June 5, 2025

**Re: M15E021G (SWQ-2025-00024) Comments Response Letter**  
**McDonald's 2000 Gibson Blvd. SE**  
**Langan Project No.: 520088901**

Thank you for taking the time to review the Erosion and Sediment Control Plan for the McDonald's restaurant located at 2000 Gibson Blvd. SE. We have addressed your comments as follows:

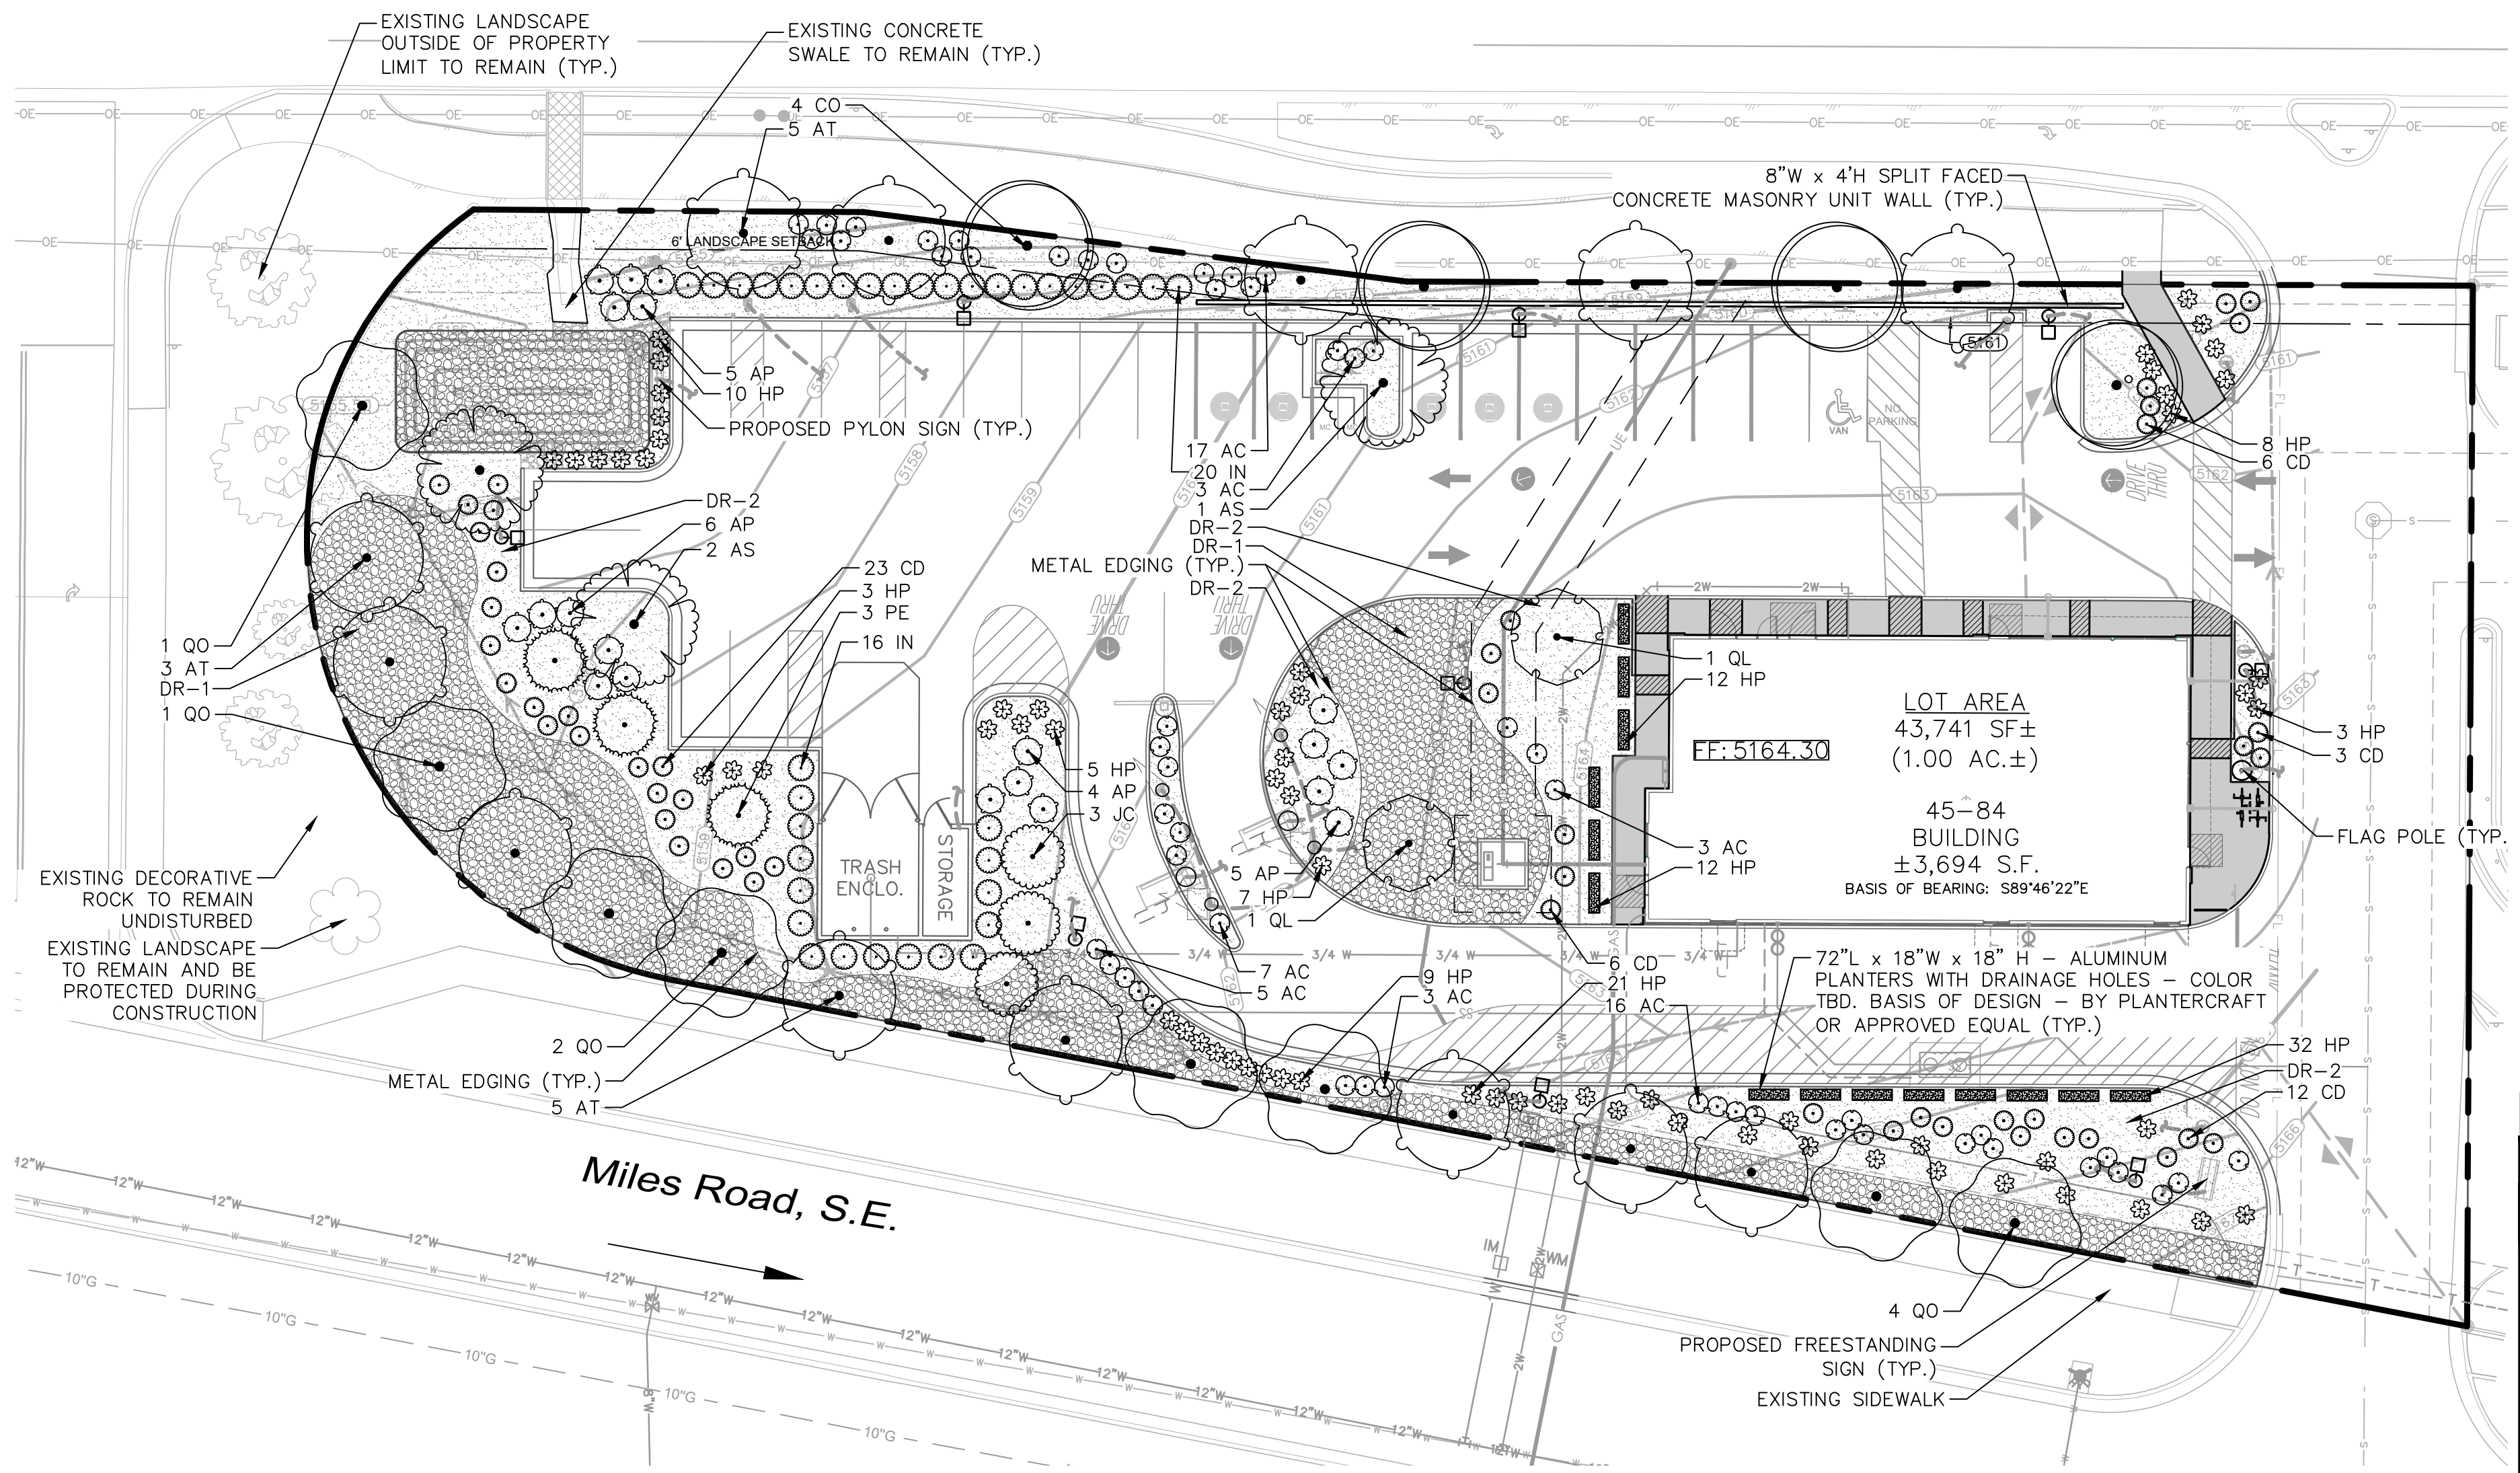
- 6) The SWPPP must include site-specific interim and permanent stabilization per CGP 9.6.1.c.i. The Landscape Plan and Work Order sheets can be used to satisfy this requirement and should be submitted separate from the ESC Plan with the application to the Stormwater Quality Section of the Planning Department, and they should be included in the SWPPP. Provide a specification on the ESC Plan for any disturbed areas not covered by the Landscape Plan.

- The Landscape Plan has been added in this resubmittal.
- 7) Update the engineer's stamp date each time the plan changes. All SWPPPs (SWPPP maps and ESC Plans) must be prepared in accordance with good engineering practices by qualified (e.g., CPESC-certified, engineers with appropriate training) erosion control specialists per CGP 9.6.1.c.iii.
